KITITAS COUNTY

MEMORANDUM

TO: All Staff
FROM: Public Works Planning Review Staff
DATE: April 22, 2020
SUBJECT: Stewart BL-20-00011

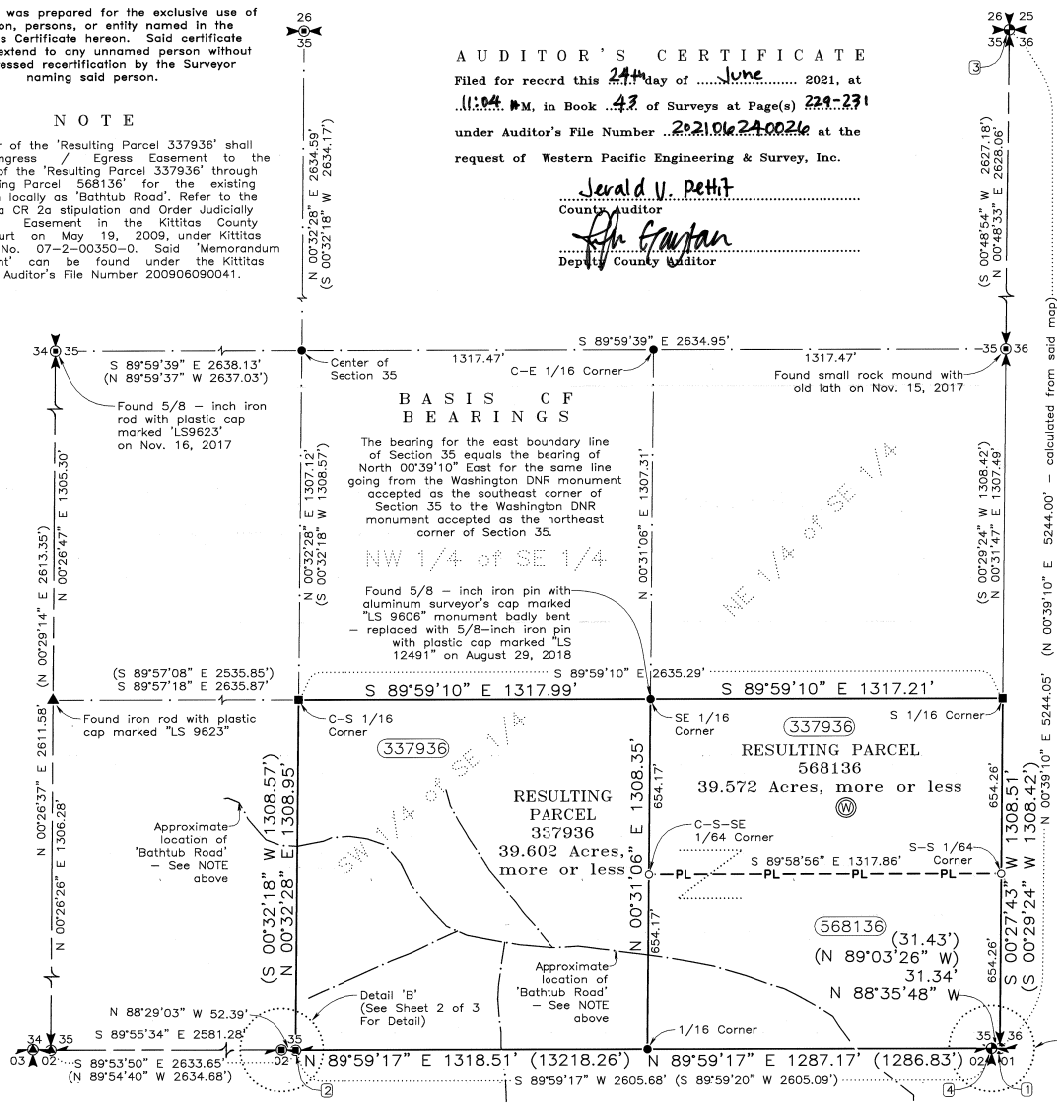
1. All access easements must be shown on the face of the BLA.
2. No access is shown on the preliminary survey to serve parcel 337936. Access must be available to all parcels included in the BLA.

1. The basis of bearings label refers to 'Said Map", but no map is referenced.
2. The auditors Certificate date should be changed to 2020.
3. The center of section and NW corner of NE1/4 SE1/4 of section are shown as set. Please confirm these were actually set, and not calc points, as they are significantly outside the subject area.
4. The 3rd symbol on the legend refers to the monument being SET May 15th. Should this be "Found May 15th?"
5. Page 3 contains a stamp inconsistent with the signature.
6. The Resulting Property Descriptions contain a date inconsistent with the signature date.
